PINS reference TR030001

# Application for the proposed Able Marine Energy Park on the south bank of the River Humber at Immingham, North Lincolnshire

Response to first stage Written Representations  
in Respect of Terrestrial Ecology and  
Nature Conservation

Figure 3
Breeding Birds Proposed Mitigation

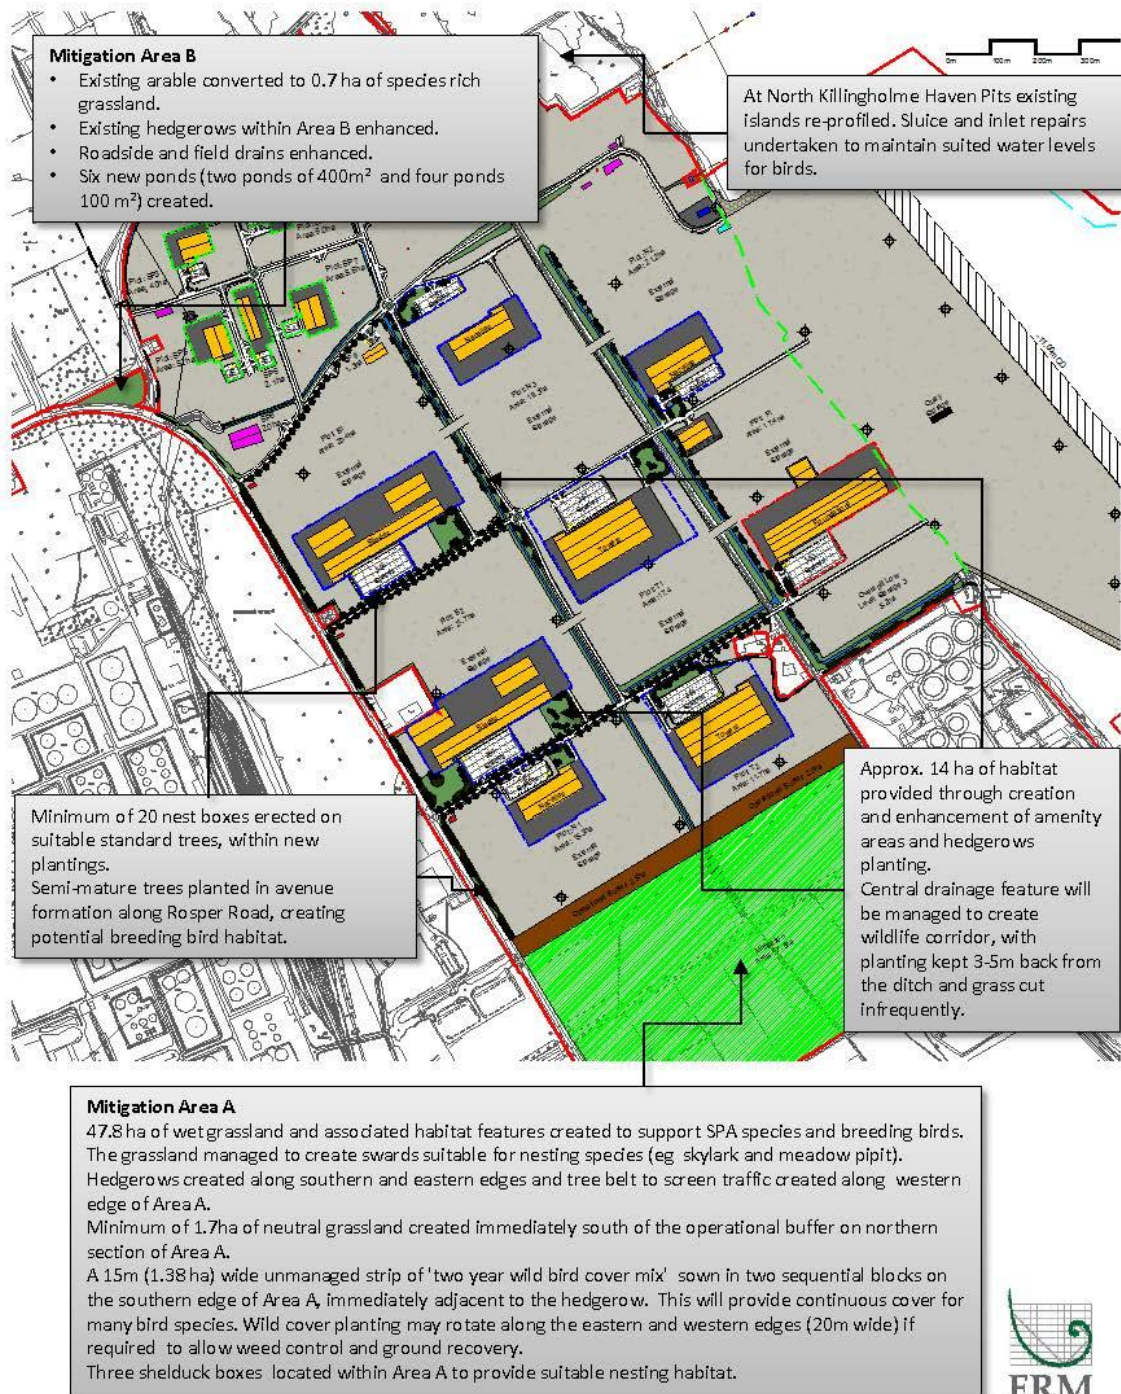
2.3 The report, however, still fails to assess the proposed mitigation, which it is claimed in the ES (para 11.9.6) will fully mitigate the identified impacts (with the exception of Skylark). In addition, it does not describe any of the residual impacts. While the report addresses some of the shortcomings that have been identified, the impact assessment

- Agreed mitigation for Lamprey and Grey Seals
- Impact of construction on NKPH (the additional note Ex 11.22 only deals with operational noise)
- Further information on mitigation for breeding birds (Ex 11.16 does not explore the adequacy of the mitigation)
- Information on flightlines between OLHF and the Estuary (para 8.70)
- Further survey work on bats (para 8.72) (Ex 11.19 contains no additional survey data)
- Details of water vole mitigation (para 8.73) (Ex 20.3 provided no detail of how mitigation will be achieved)
- Details of the operational buffer alongside mitigation area (A) (Ex 20.3 provided no detailed information).
